**RE: Existing Septic System Inspection HTE# 10-5-25249**

An attempt was made to evaluate your property for the purpose of issuing an Existing Tank Permit. The evaluation could not be completed for one or more of the following reasons.

SITE PLAN APPROVAL

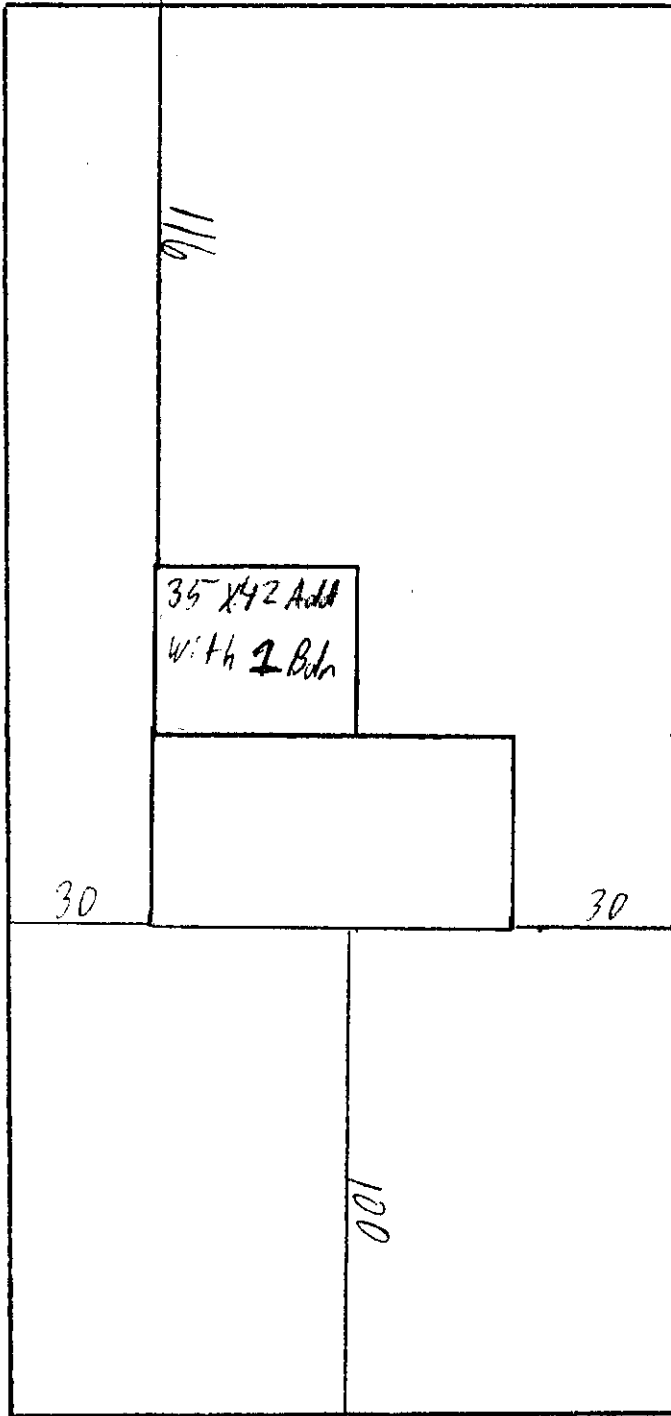
- 1. Uncover outlet lid on septic tank and break seal (*\$25.00 fee incurred*)
- 2. Have system pumped out
- 3. Replace sanitary T
- 4. Other – Addition must be a minimum of 5 feet from septic system and/or drain field. Please call me at the number listed below between 8:00 a.m. to 9:00 a.m. to discuss.**
